Recommendation Report for Planning Permission for Works or Extension to a Dwelling

REF NO: WA/48/26/HH

LOCATION: Ballina, The Street
Walberton
BN18 0QB

PROPOSAL: Proposed replacement rear side extension. Front porch roof extension. Front elevation and rear extension to be rendered off white colour. This application may affect the setting of a Listed Building and the character and appearance of the Walberton Green Conservation Area.

North Facing (front) Elevation

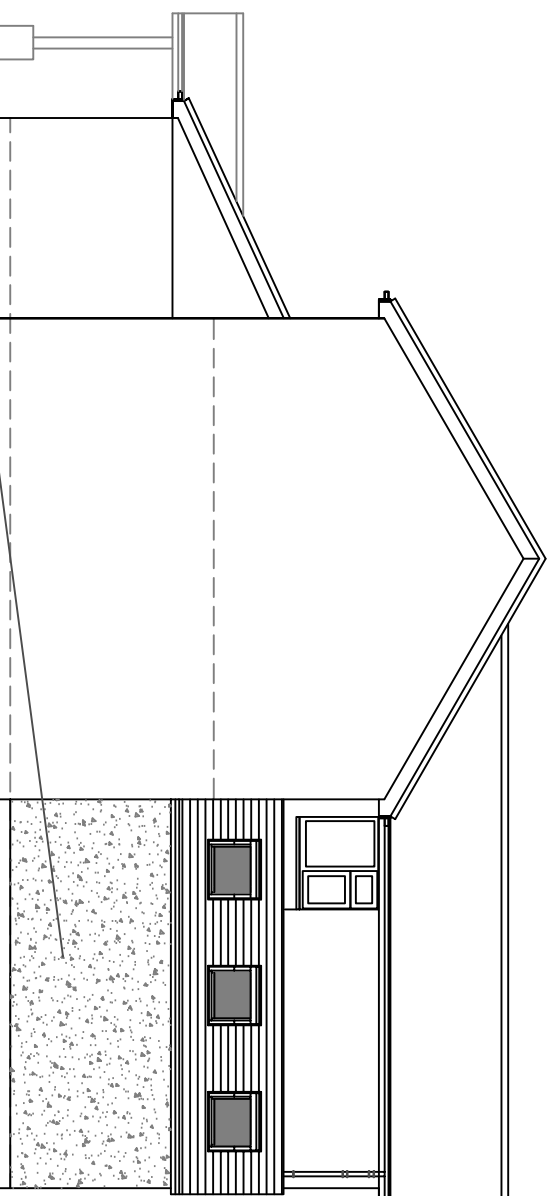
Similarly to the side and rear extension, a pitched roof is proposed to replace the existing flat roof serving the porch. While greater in height (3.8m rather than 2.6) the pitched roof will avoid the "bolt on" appearance that flat roof porches can create, in accordance with the ADG. The pitched roof will result in a softer, congruous relationship with the street scene compared to the bulky, angular existing structure. A new open porch canopy is proposed, with a pitched roof set atop two supporting posts. Set down from the top of the new porch roof and lightweight in appearance, the canopy would be a subservient and sensitive addition.

Part of the proposal involves the introduction of off-white render to the entirety of the front elevation and replacement side and rear extension. Render is not a common external finish in the locality, with most dwellings exhibiting red brick. However, the neighbouring dwelling (Willow Cottage) is finished in cream painted brick. There is also variation in material palate across the road at Honeywood House, where white paint is used on the front elevation. Considering the varied materials in the locality, the render would not result in undue harm to design or visual amenity.

Dove grey windows are proposed as part of the amendments. It is noted that grey windows have been used within the adjacent conservation area and at Honeywood House. Given that the host dwelling is a more modern addition than the adjacent listed cottages, and the existing variation within the street scene and wider area with regards to materials and windows, the proposal would not result in harm to character or visual amenity.

Ground Floor Plan

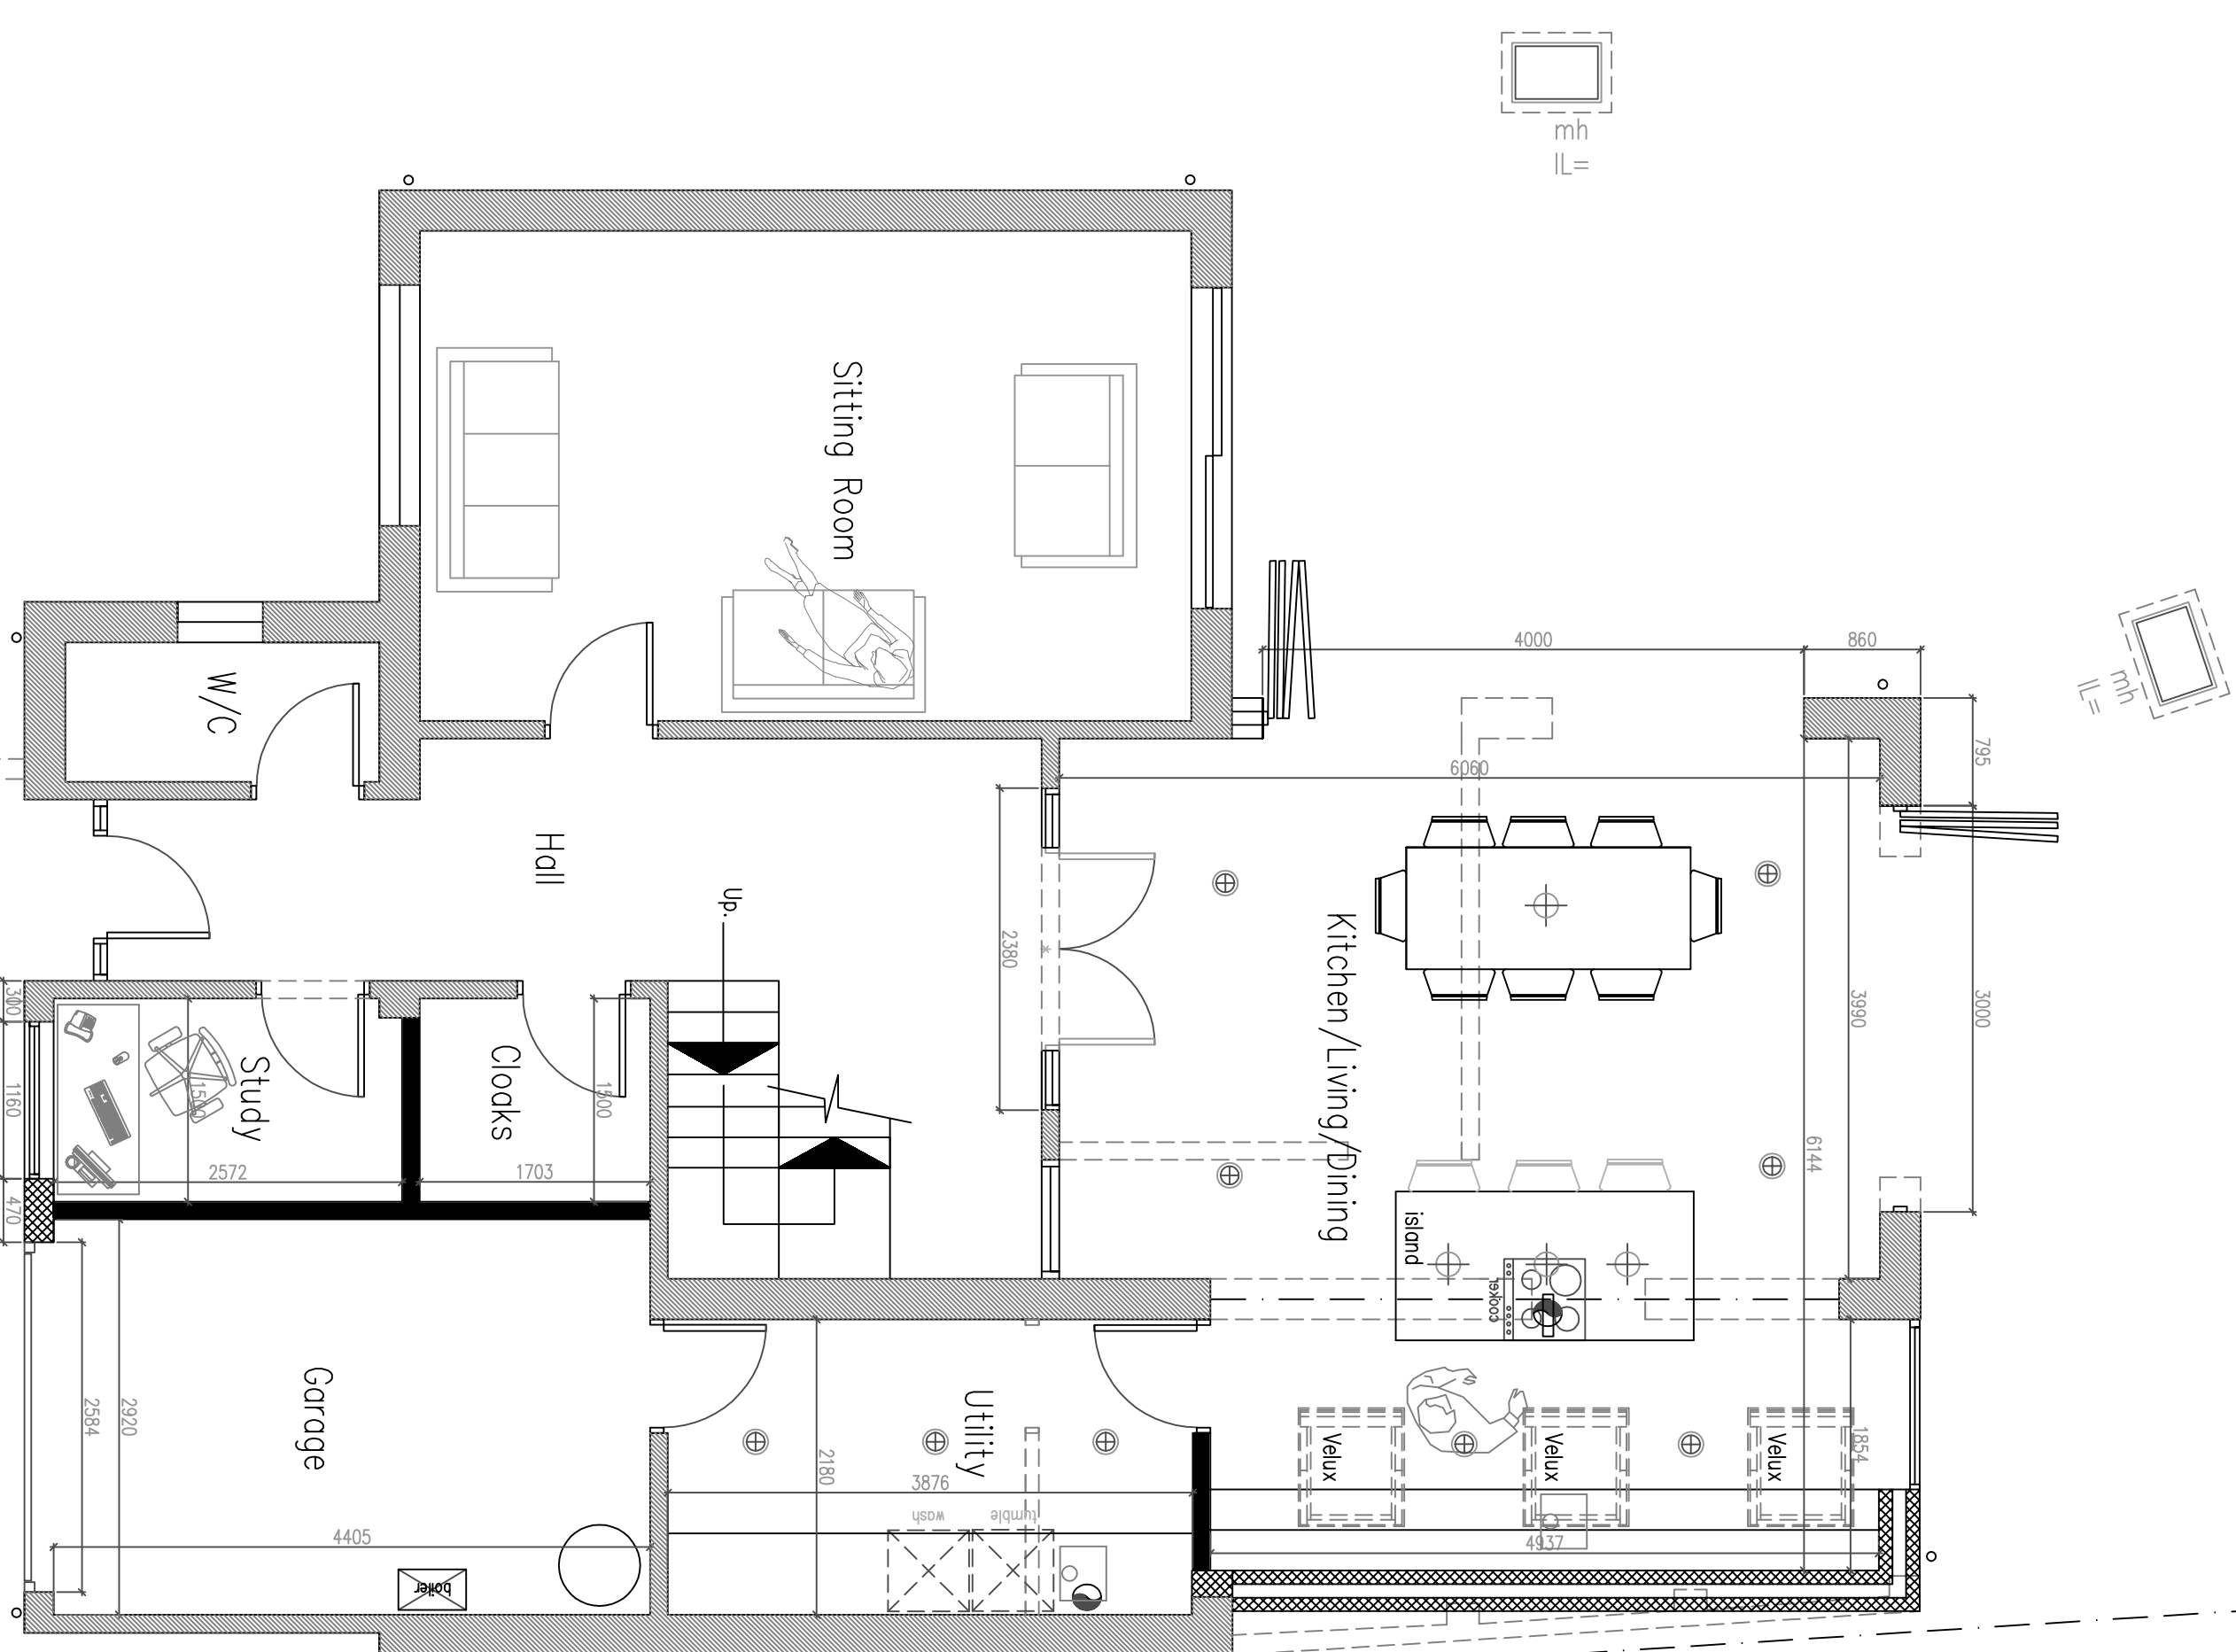
The proposed side and rear extension would be equal in depth (5.14m, in line with the rear wall of the existing kitchen). The replacement western flank elevation would be set in by 0.35m (from the remaining western flank) and run perpendicular to the rear wall. The side extension would include a pitched roof with an eaves height of 2.6m, equal to the existing shallow pitched flat roof at a height of 2.6m. The addition of the pitched roof is positive, reflecting built form in the locality. Three rooflights would be set centrally and symmetrically on the roof slope, in accordance with Arun Design Guide (ADG) advice.

Minor alterations to fenestration are proposed; new folding doors on the east and south elevations are proposed, as well as amendments to the garage door and fenestration serving the rear and side extension. The amendments are uncontroversial and would not result in harm to design or visual amenity.

Given that the replacement side and rear extension is, albeit marginally, smaller in footprint than the existing extension and incorporates a pitched roof sloping away from neighbouring properties, there would be no harm by way of overbearing or overshadowing impacts. Similarly, the front porch canopy and new pitched roof would be retained well within the site, resulting in no harm to neighbouring amenity by way of overbearing or overshadowing.
